IMAX Redevelopment

SSD 5397

Submission to NSW Department of Planning and Infrastructure
28 October 2013

City of Sydney

Figure 4. Zone of influence plan

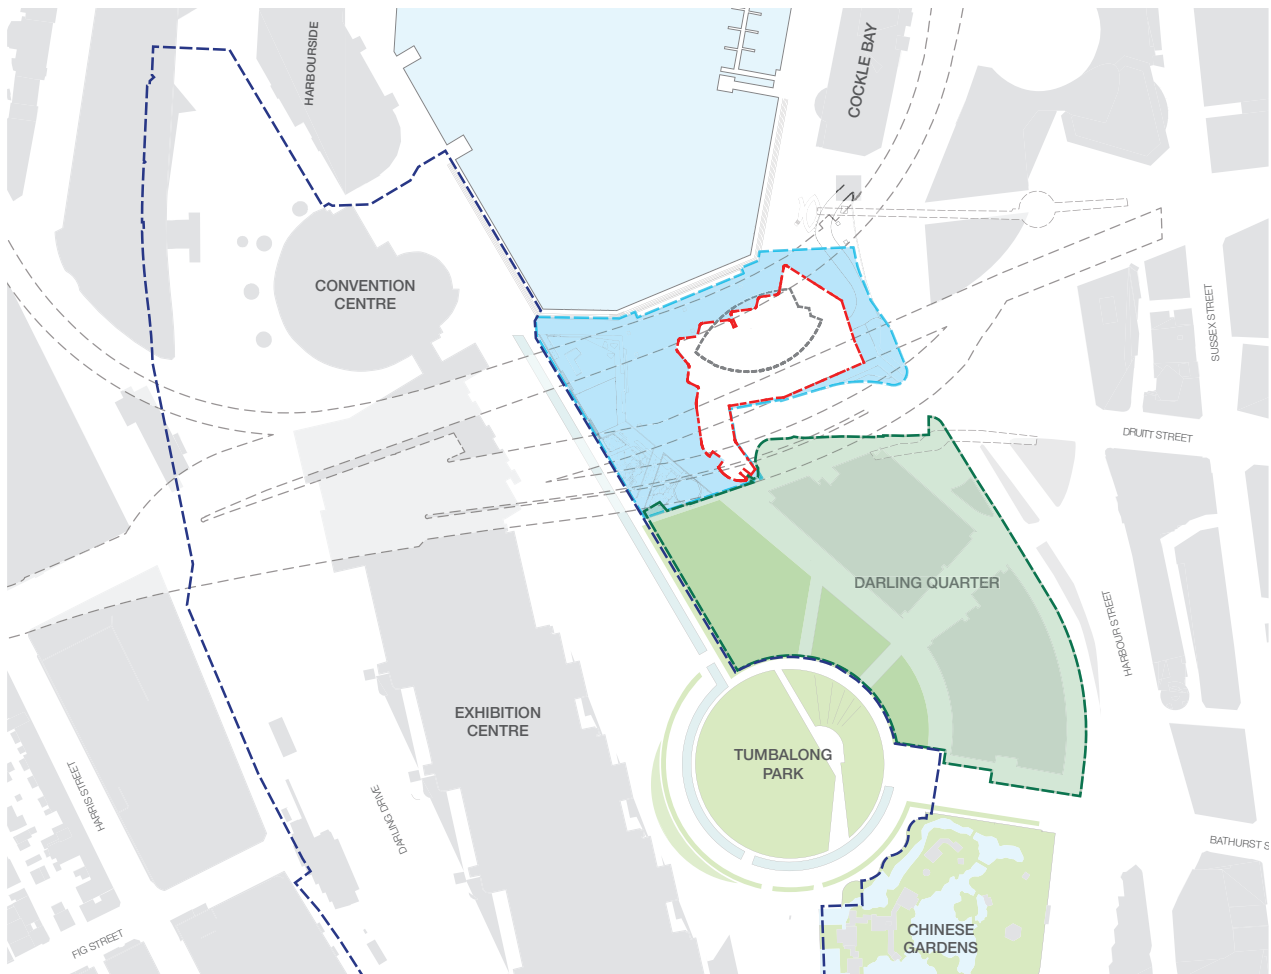
The event space, as nominated in the Landscape Report, is primarily within the pedestrian circulation zone to the immediate west of the building. A smaller viewing area is further west, between 30m and 60m from the screen and probably too far from the screen to be worthwhile.

A crowd gathered to watch the screen has the potential to disrupt major north-south pedestrian movements to and from the area if not sufficiently controlled. The Landscape Report indicates that access will be maintained along the building edge under the façade. However, the space appears very limited and may not be sufficient for an influx of thousands of people (from the approved exhibition and entertainment facilities or a major event around the Harbour) bound for Chinatown, the CBD, Cockle Bay Wharf, King Street Wharf, Barangaroo, etc.

The need for a large event space in this location is questioned for the following reasons:

- The location of the event space conflicts with pedestrian circulation
- The seating/viewing edge is over 30m from screen
- There are many large event spaces in the immediate vicinity

Consideration needs to be given to removing or containing the event space.

If the event space is retained, a Pedestrian Plan of Management should be prepared and implemented during major events. The Plan of Management should be based on credible estimates of pedestrian counts and desire lines from the proposed development, the approved exhibition and entertainment centres and general background pedestrian traffic.

1 CITY SCREEN LOCATION
1:200

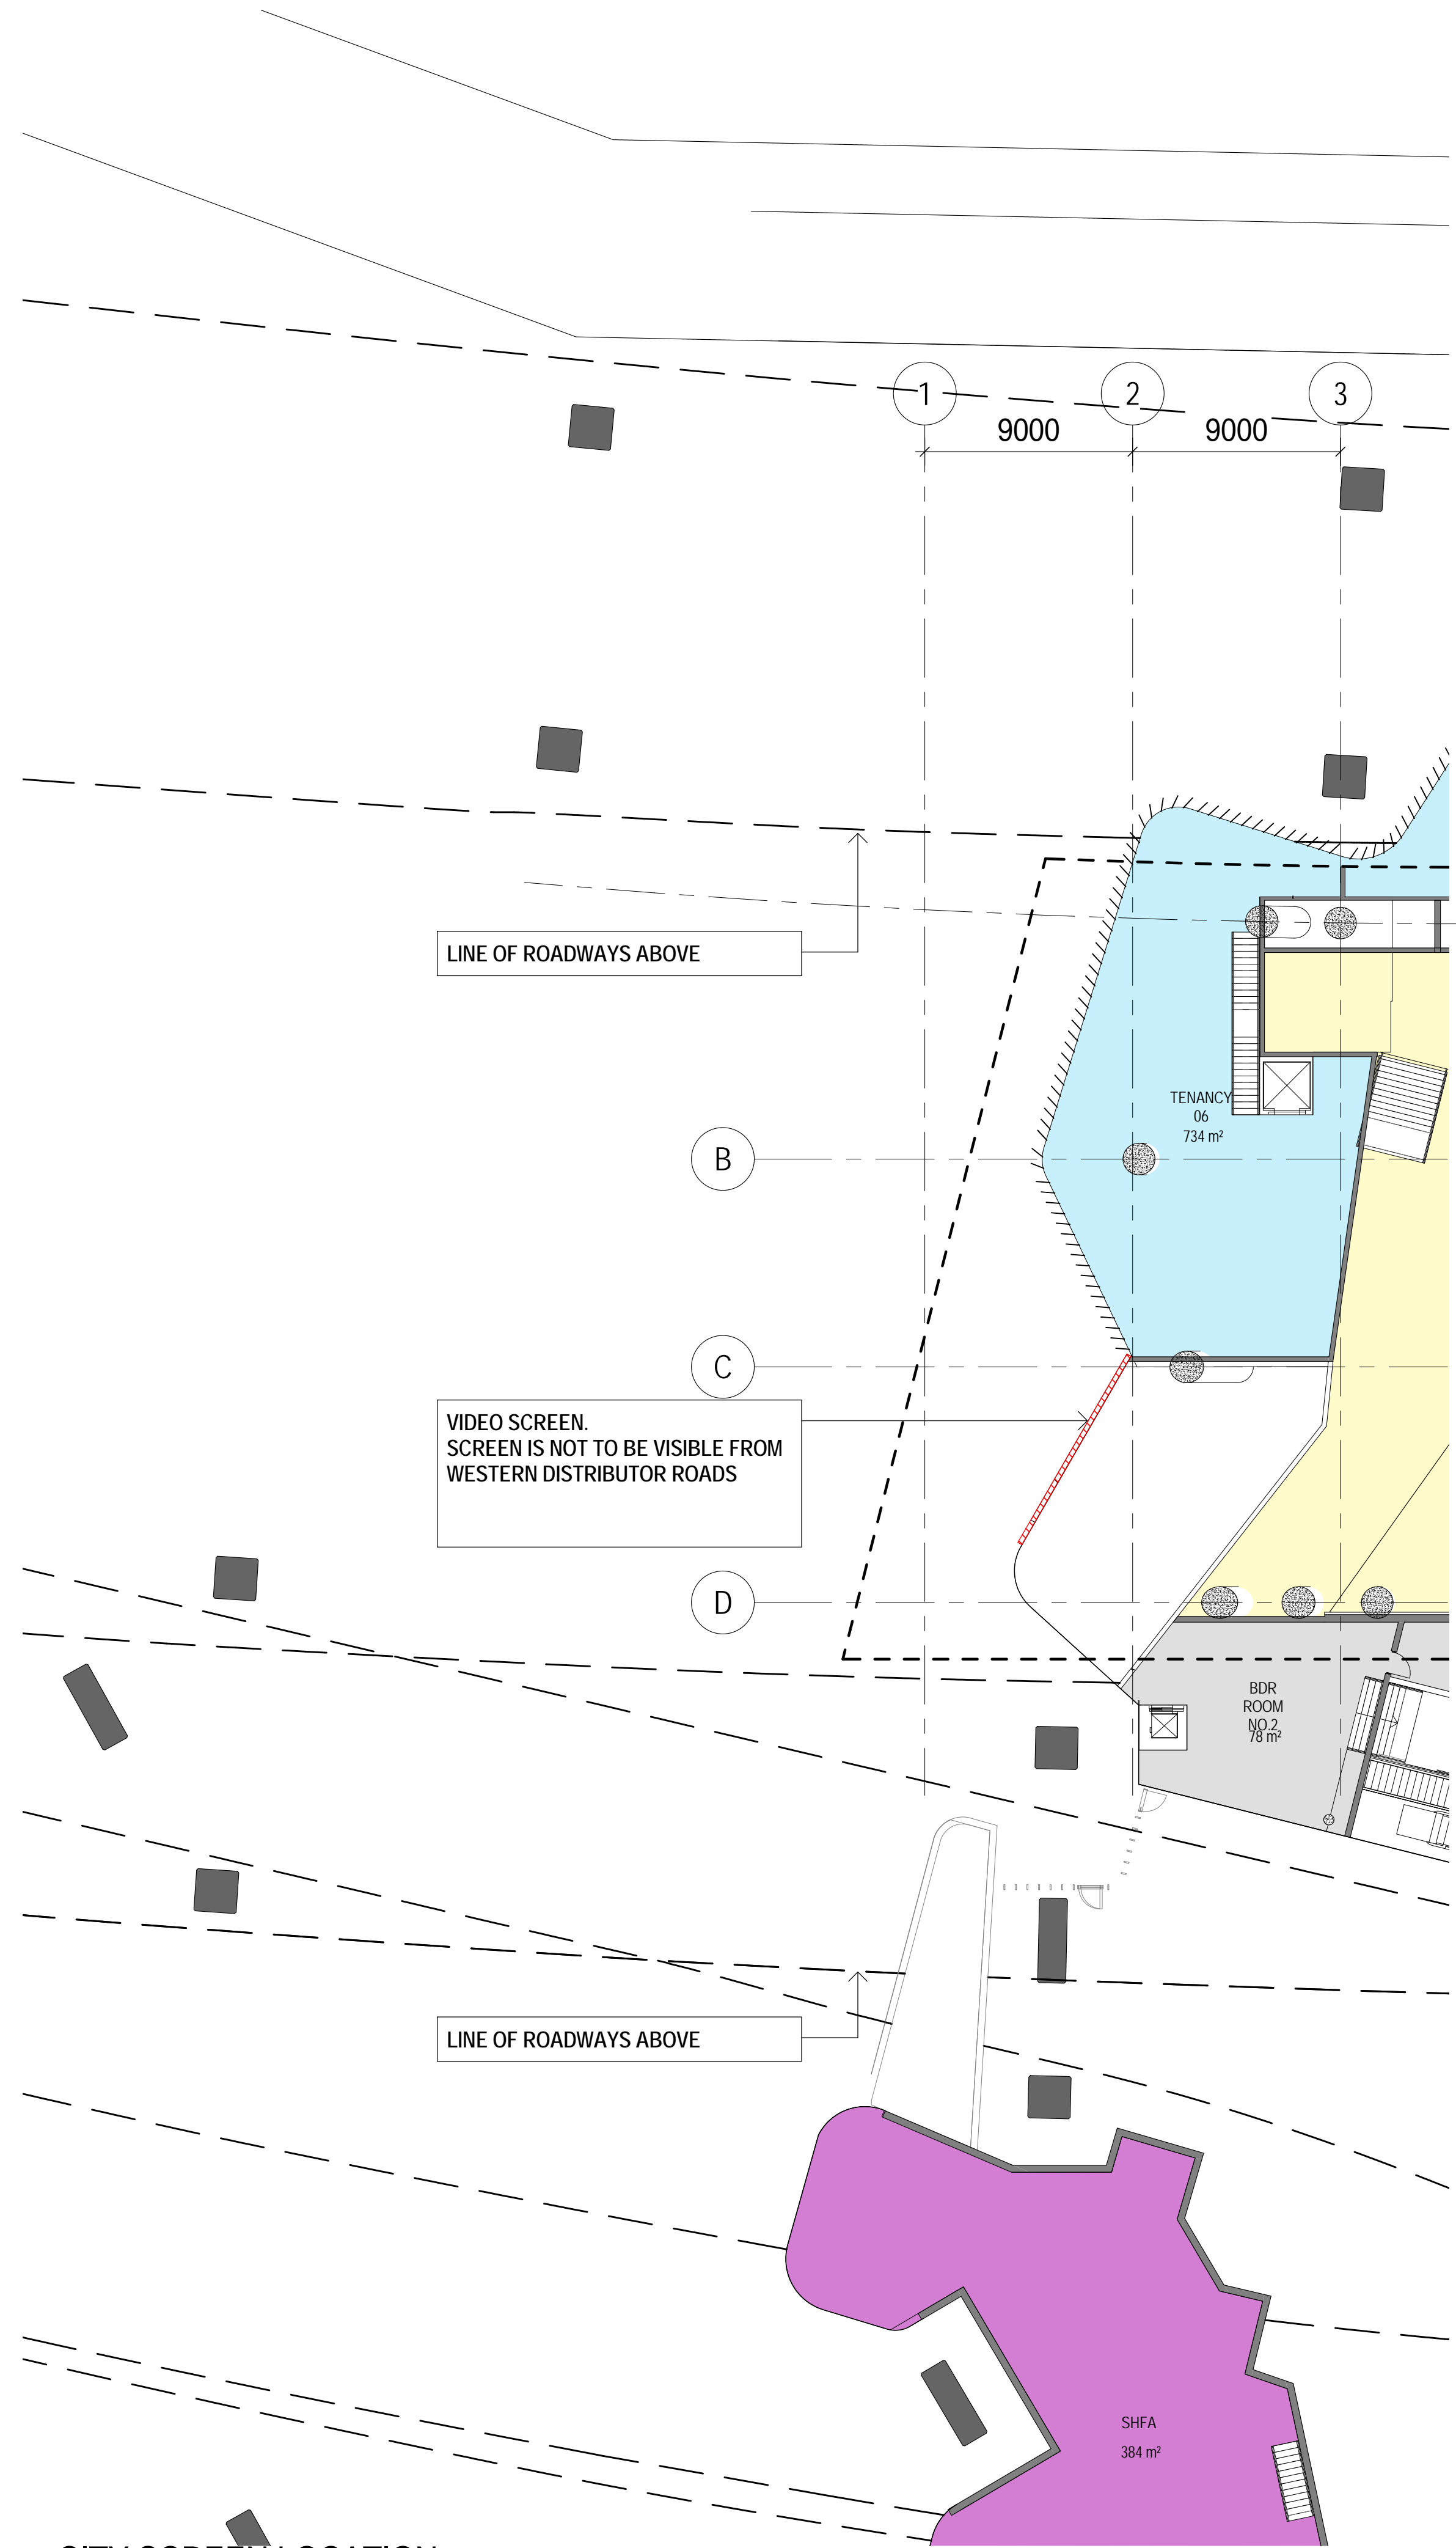
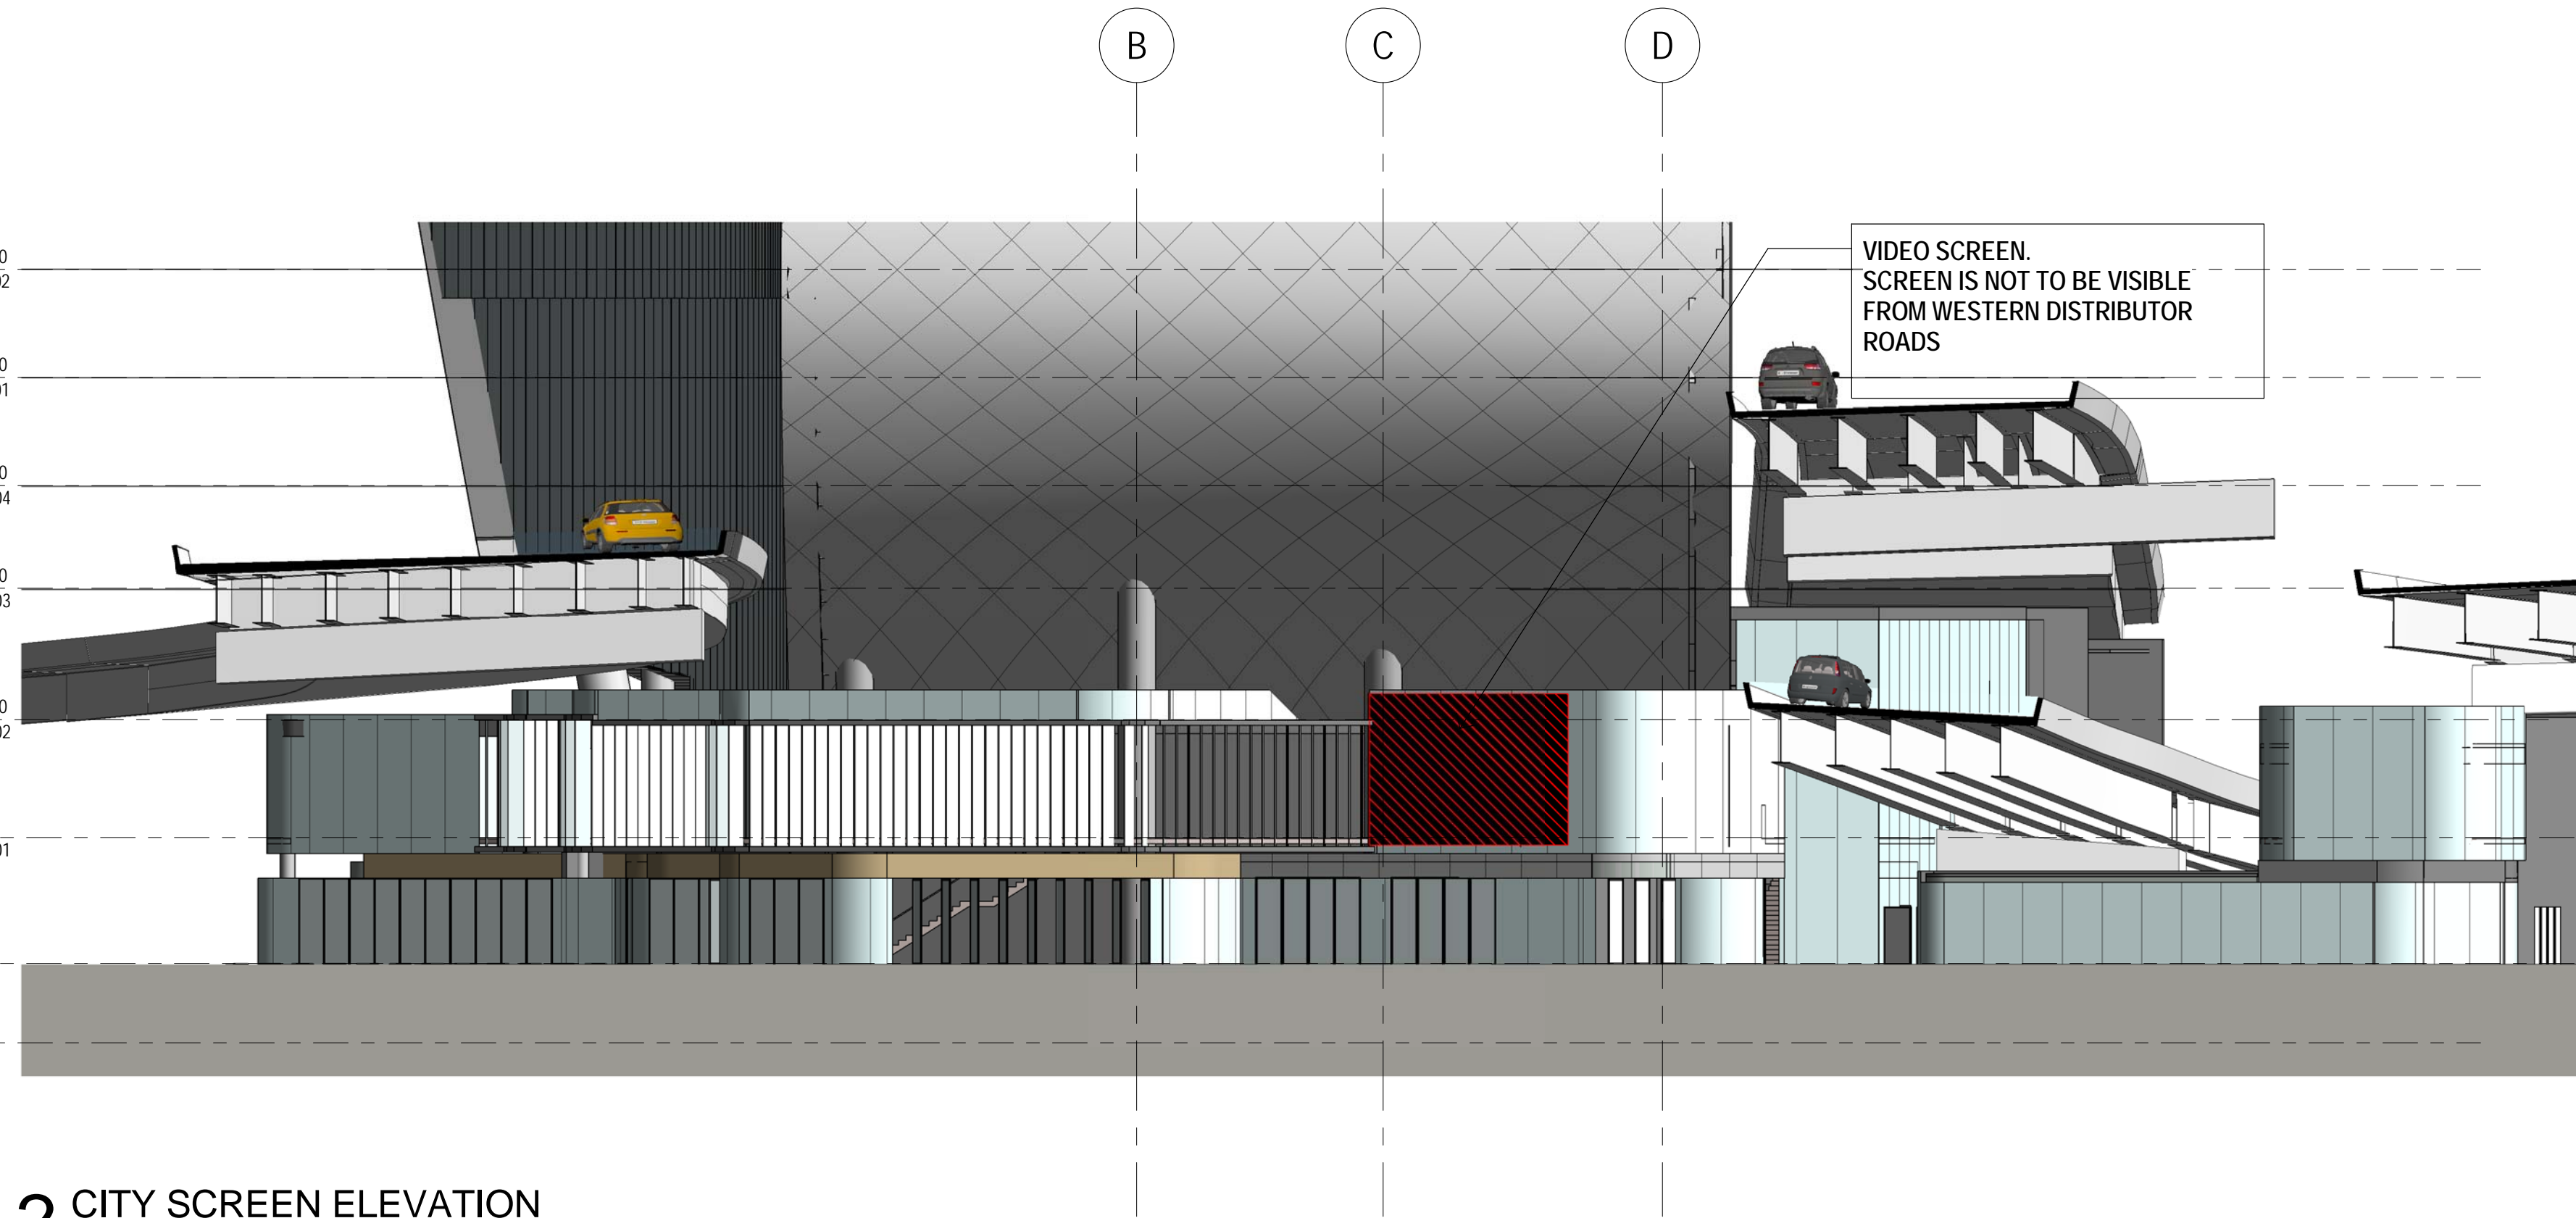
The Urban Design Report states that the viewing angle for the cinema screen will be controlled to not contravene Roads and Maritime Guidelines for animated signage visible from roadways. However, it appears that the angle shown within the drawings easily facilitates views, and driver distraction, for vehicles on the eastbound expressway into the city. A SEPP 64 Assessment and commentary on compliance with RMS Guidelines should be provided.

An assessment against the heads of consideration in SEPP 64 – Advertising and Signage and RMS Guidelines should be carried out to determine whether the proposed large screen will be a distraction hazard to vehicles.
